Arun District Council  
Arun Civic Centre  
Maltravers Road  
Littlehampton  
West Sussex BN17 5LF  
Planning & Building Control General Enquiries  
Tel: (01903) 737756 Fax: (01903) 730442  
Dx: 57406 Littlehampton  
Minicom: 01903 732765  
e-mail: [planning@arun.gov.uk](mailto:planning@arun.gov.uk)  
website: [www.arun.gov.uk/planning](http://www.arun.gov.uk/planning)

1st July 2021

Application No: EP/64/21/PL  
Site Address: 111 Sea Road East Preston BN16 1NX  
Description of works: Alterations to existing premises and change of use to Office. This site is in CIL Zone 4 (Zero Rated) as other development.

| Revisions                                                                                                                                                    |             |    |
|--------------------------------------------------------------------------------------------------------------------------------------------------------------|-------------|----|
| Drawing Number: 1316.01                                                                                                                                      |             |    |

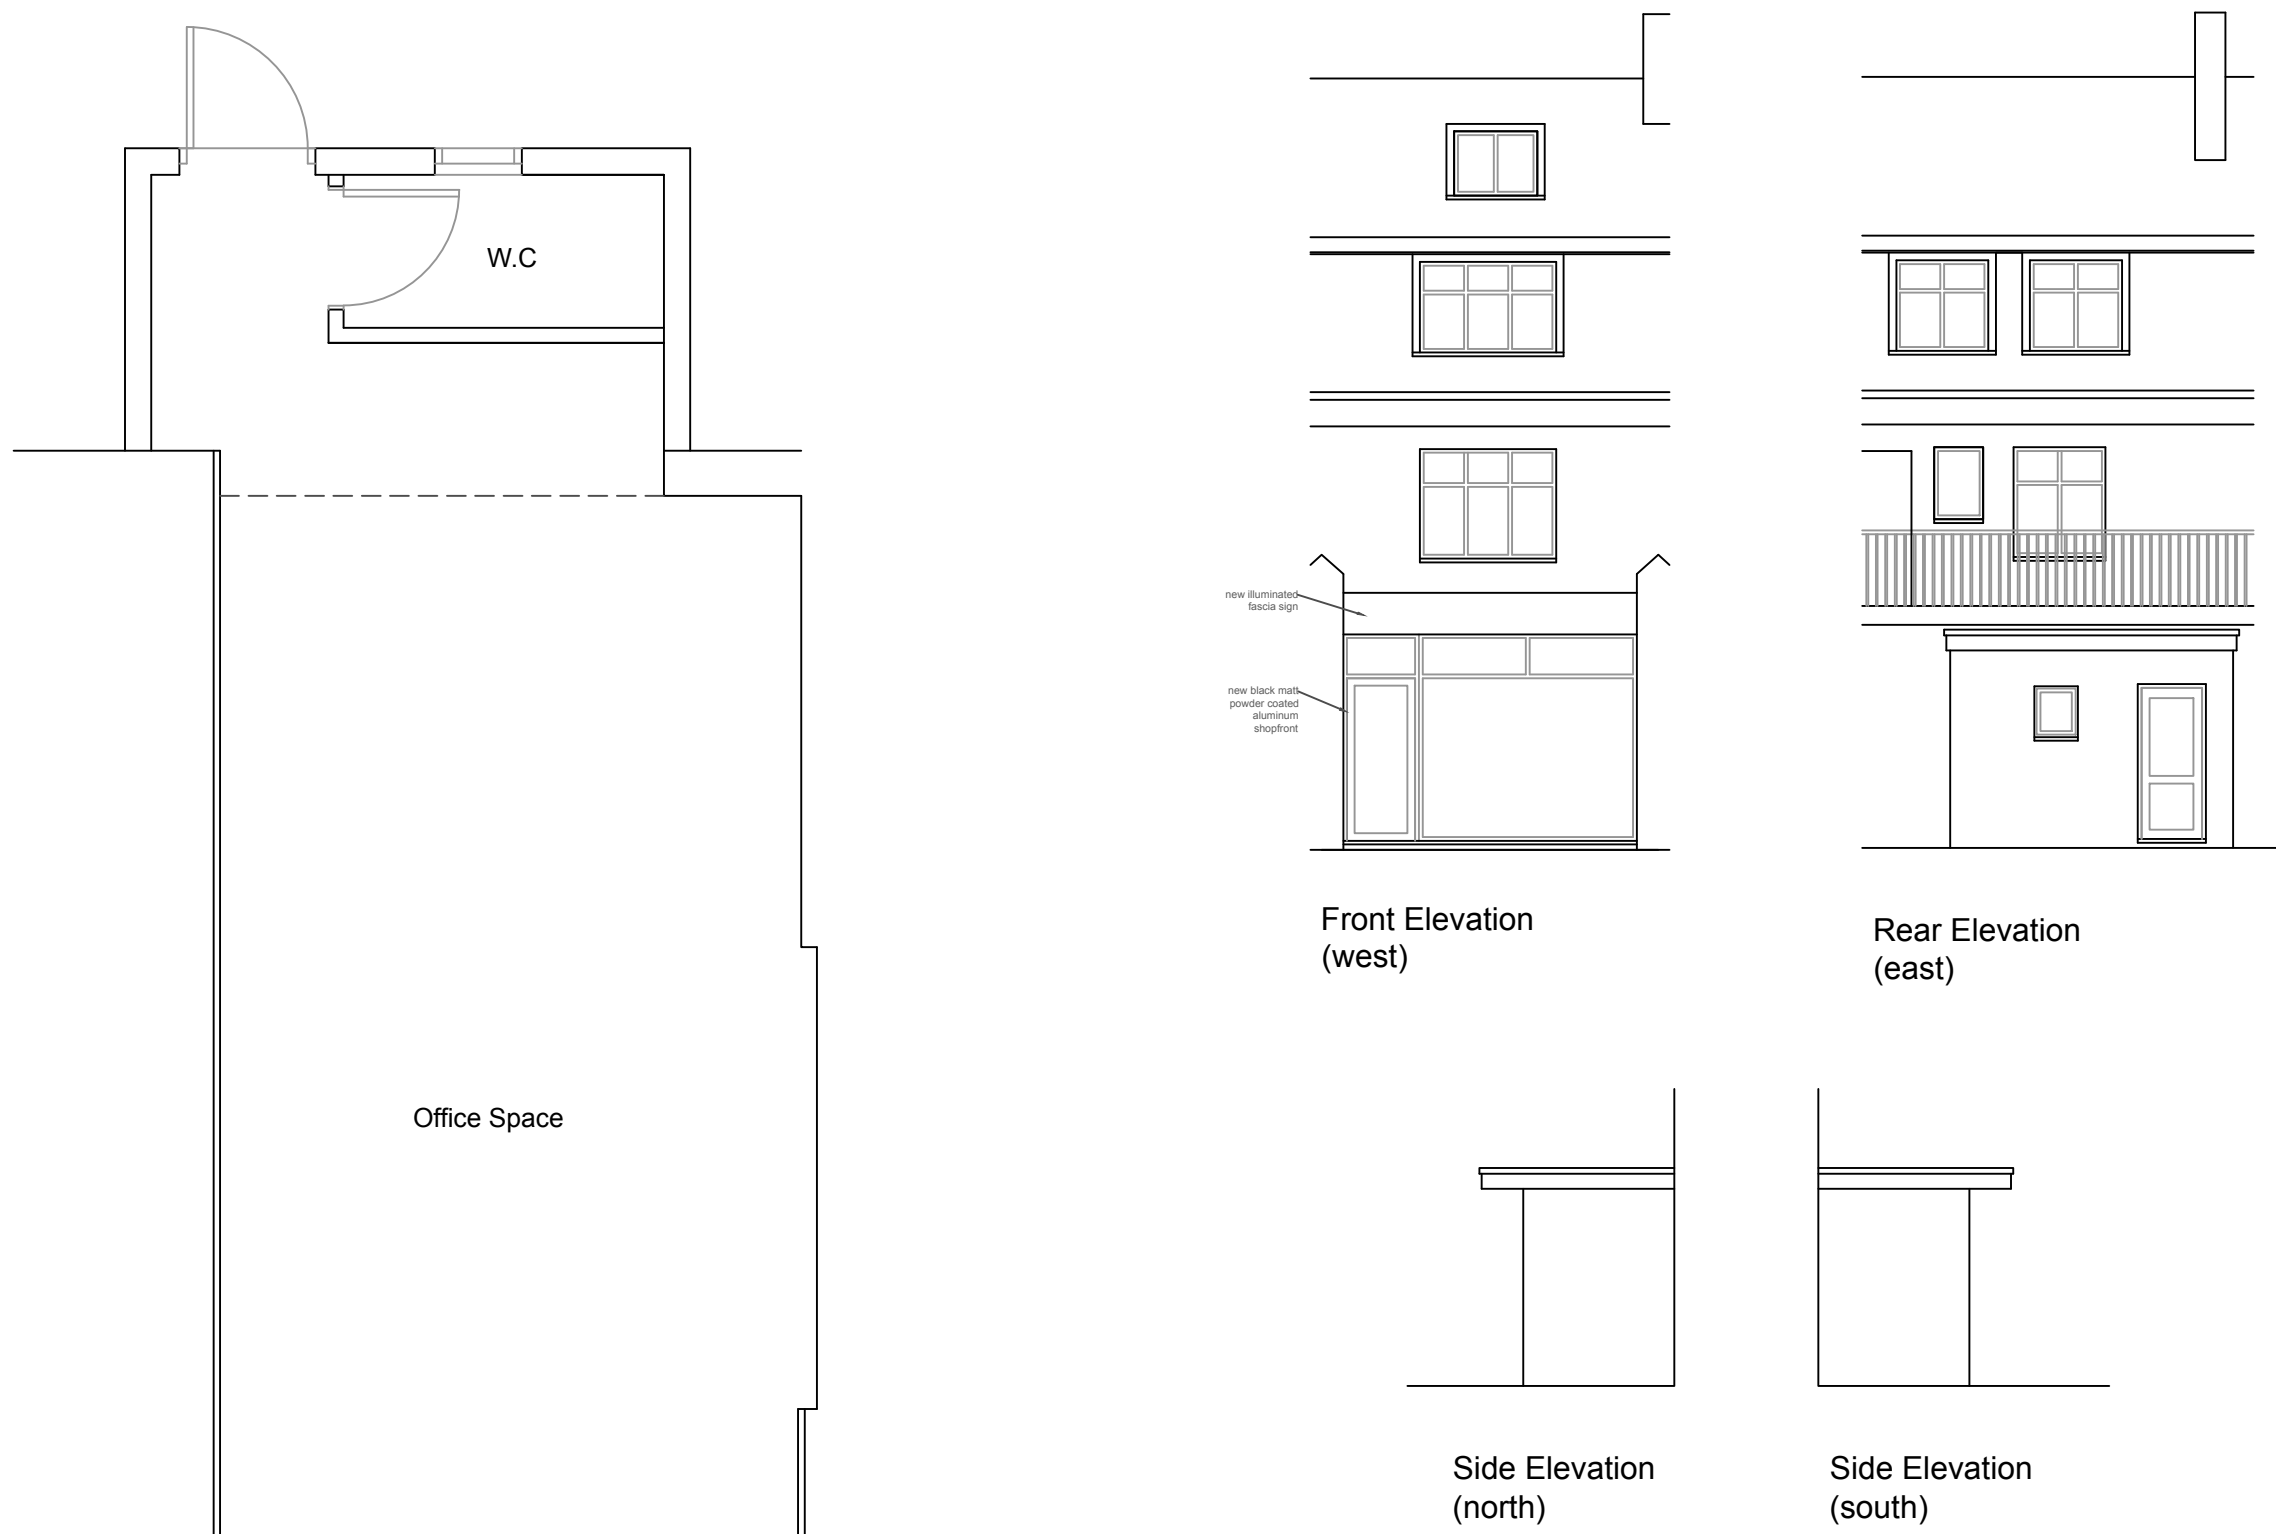
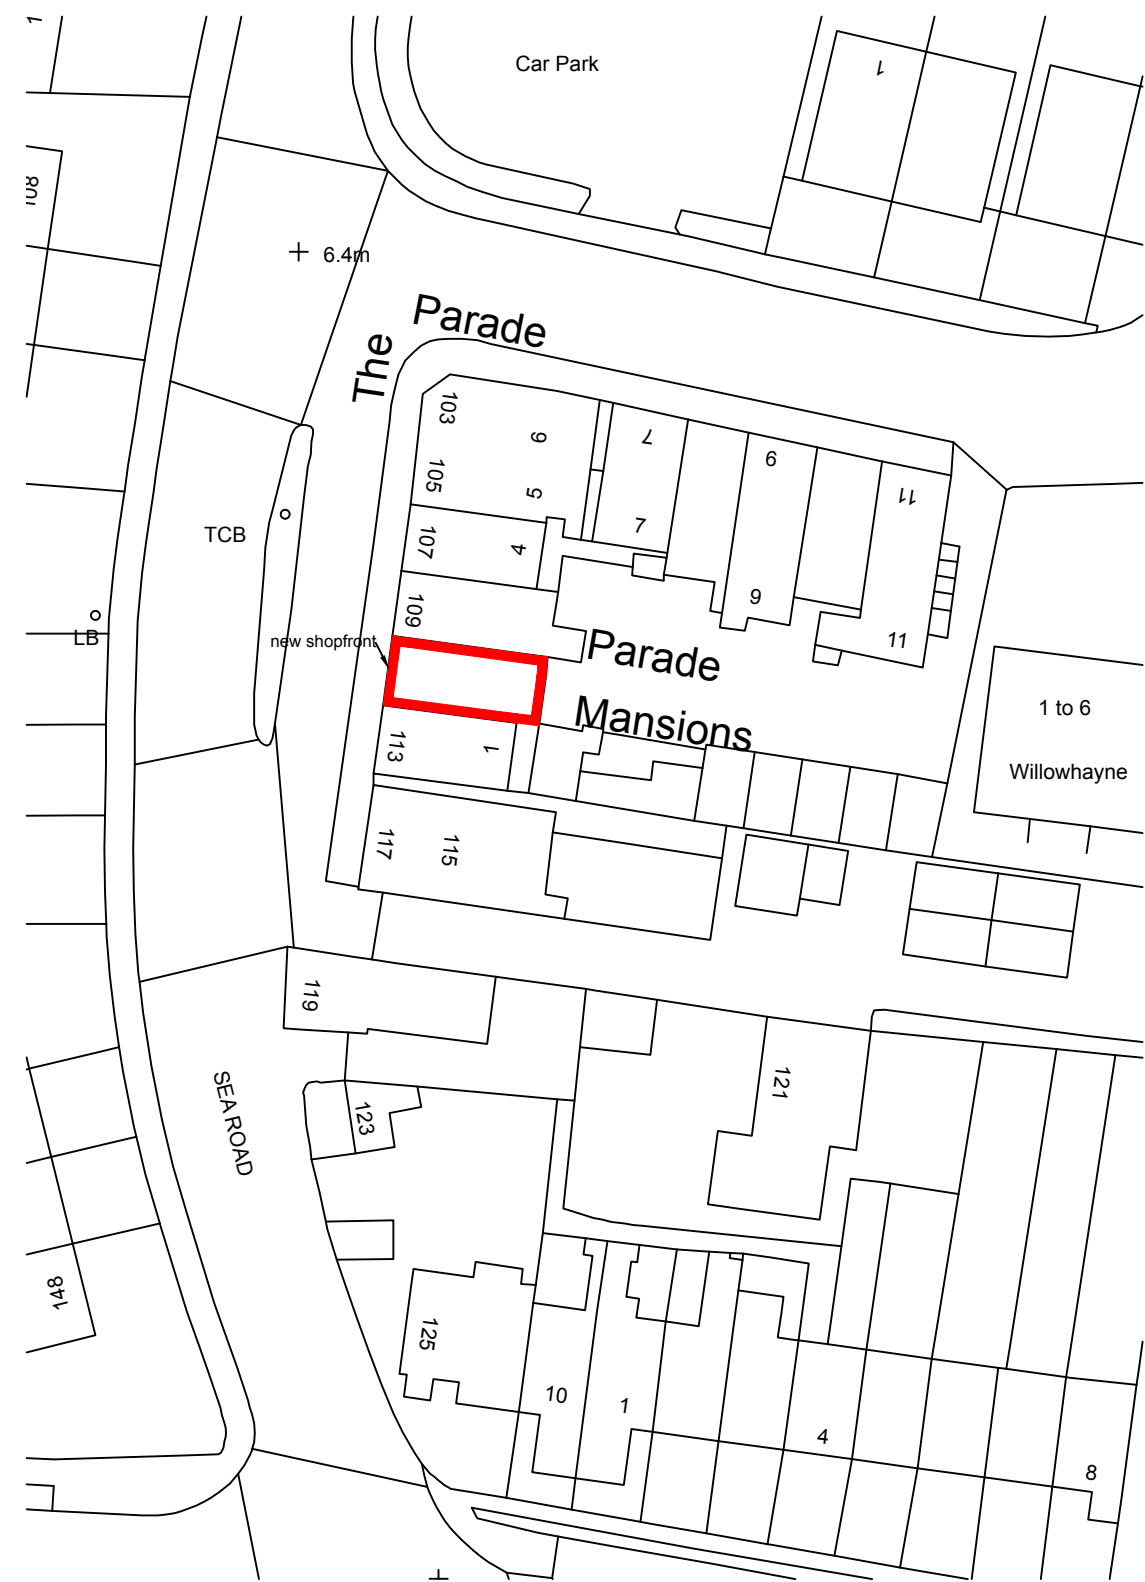
The choice of Black Aluminium for the shopfront would not be in keeping with the majority of local shopfront premises which have retained some form of light colouring in their window-framing.

The council is confused by the proposals for the back of the building referring, as they do, to an existing rear extension which was smaller than that recently built, thus making the submitted plans incorrect. The council is concerned about the rear extension newly extending beyond the depth of the walkway servicing the flats above this parade of shops. The extension appears to have been built around one of the uprights supporting the walkway; we are unsure how this can be allowed.
